WEST SUSSEX COUNTY COUNCIL CONSULTATION

TO:	Arun District Council FAO: Maria Tomalova
FROM:	WSCC - Highways Authority
DATE:	25 February 2021
LOCATION:	Eastmere Stables, Eastergate Lane, Eastergate, PO20 3SJ
SUBJECT:	BN/7/21/PL Change of use of existing equestrian yard to storage (Use Class B8). This site is in CIL Zone 3 (Zero Rated) as other development & is a Departure from the Development Plan.
DATE OF SITE VISIT:	N/A
RECOMMENDATION:	Advice
S106 CONTRIBUTION TOTAL:	N/A

SITE LAYOUT.

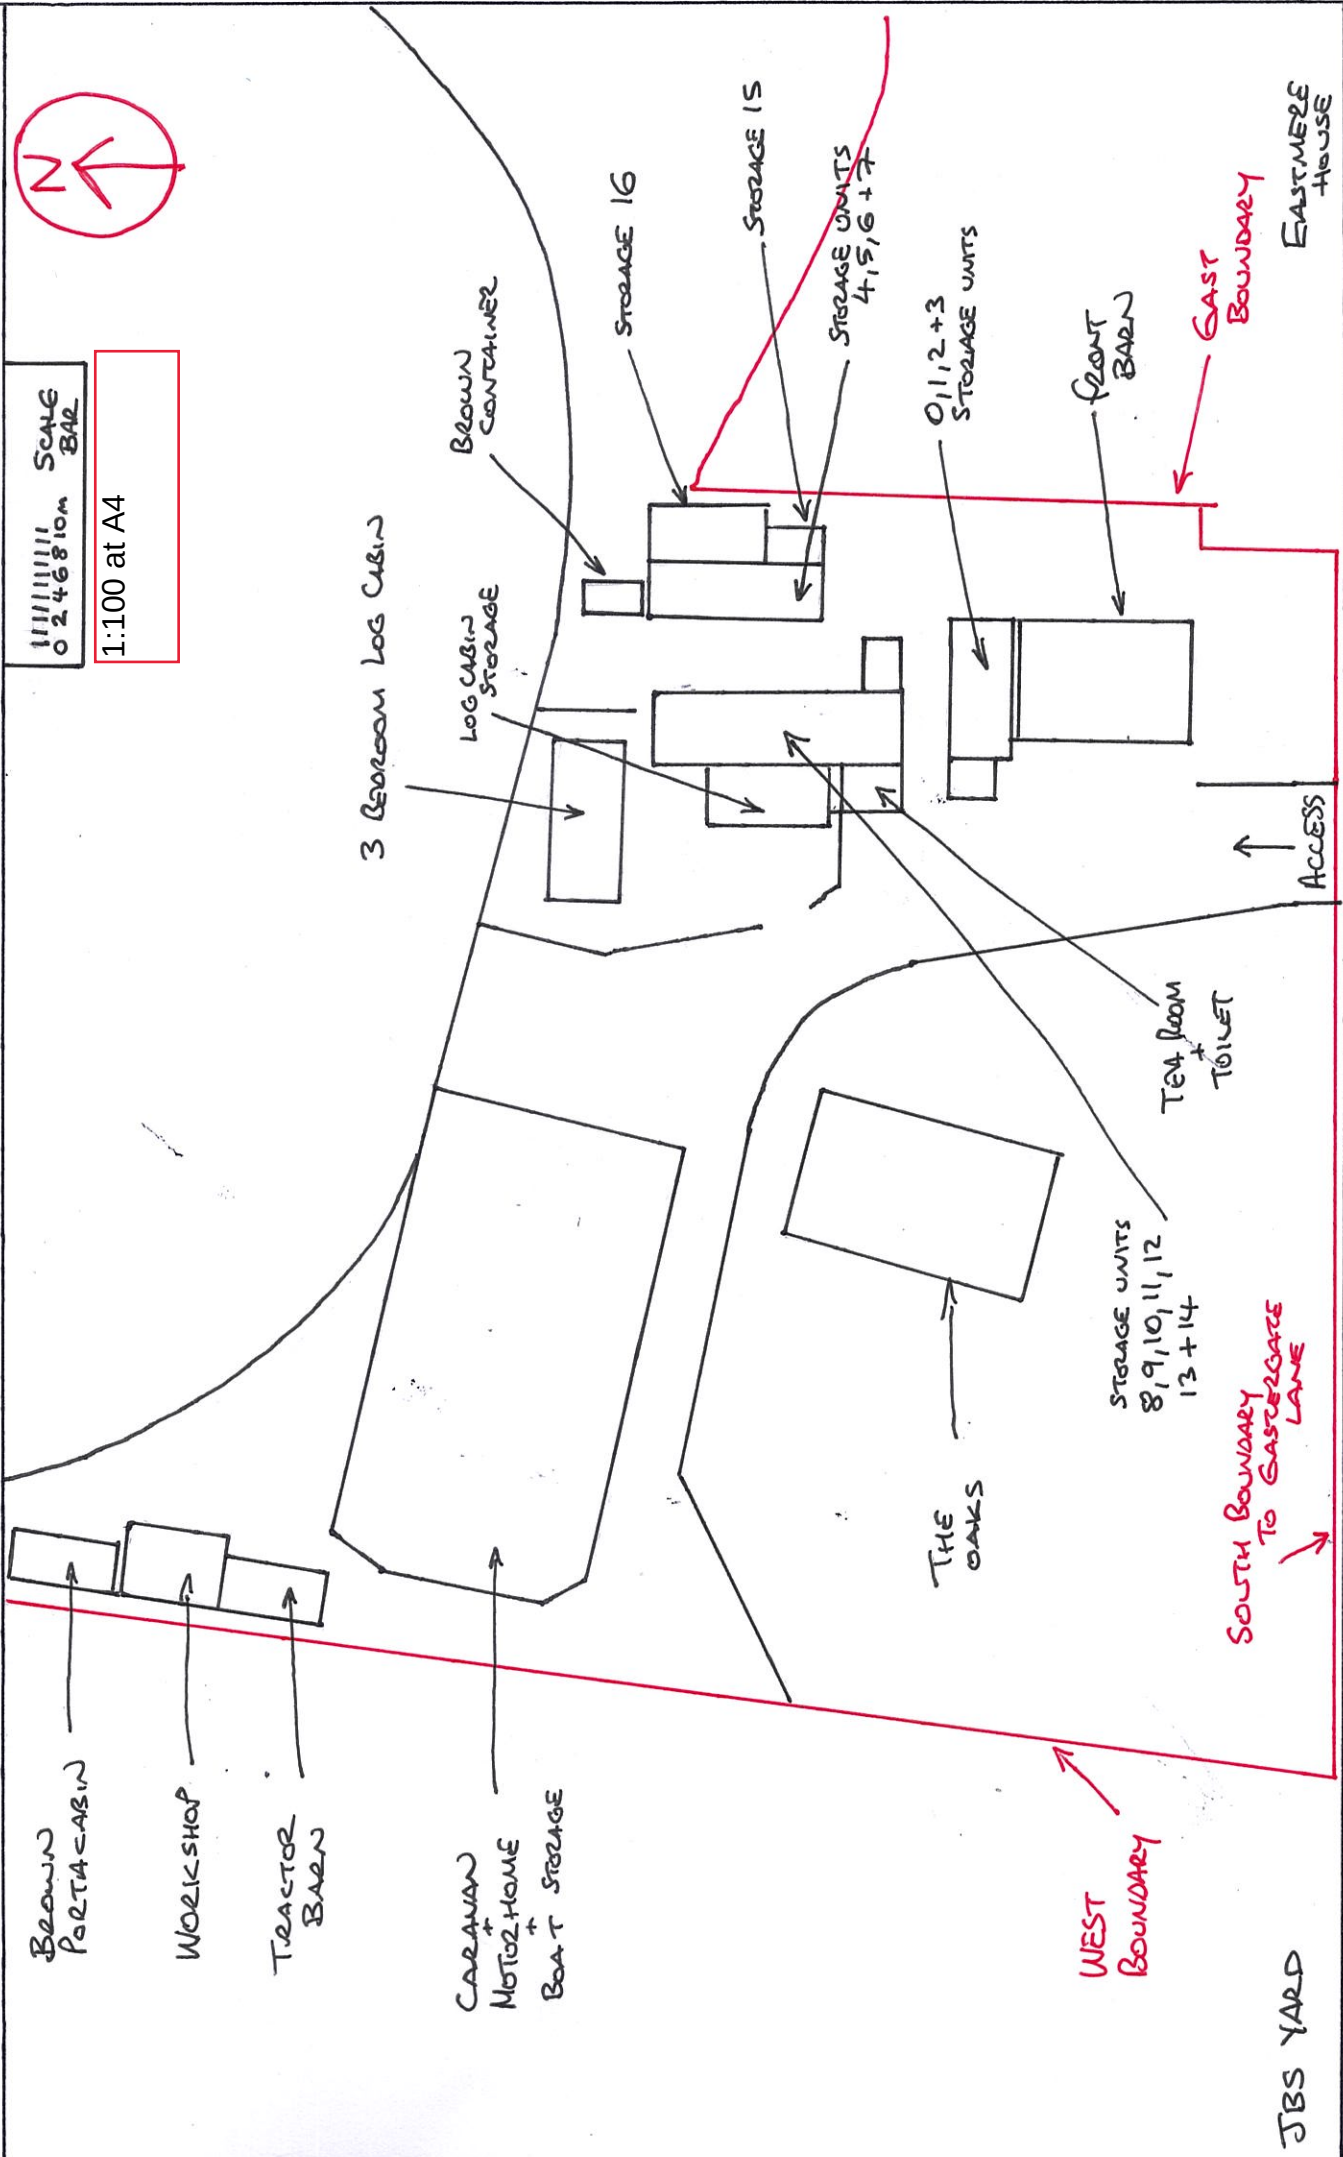
The applicant states that the site is not served by a formal parking area, but instead that parking is accommodated informally throughout the site. Under WSCC parking standards for B8 use, one parking space should be provided per 100 sqm of floor space. Therefore, the LHA would expect a

provision of five parking spaces for the storage units, and eight parking spaces for the outdoor storage area. From inspection of the plans and local mapping, there appears to be sufficient space on-site for this parking demand to be accommodated. In addition, due to the nature of the proposed storage use, whereby visits may be ad-hoc or seasonal, the LHA considers the informal parking arrangement to be acceptable in this instance. There is also plentiful space on-site for turning to be achievable.
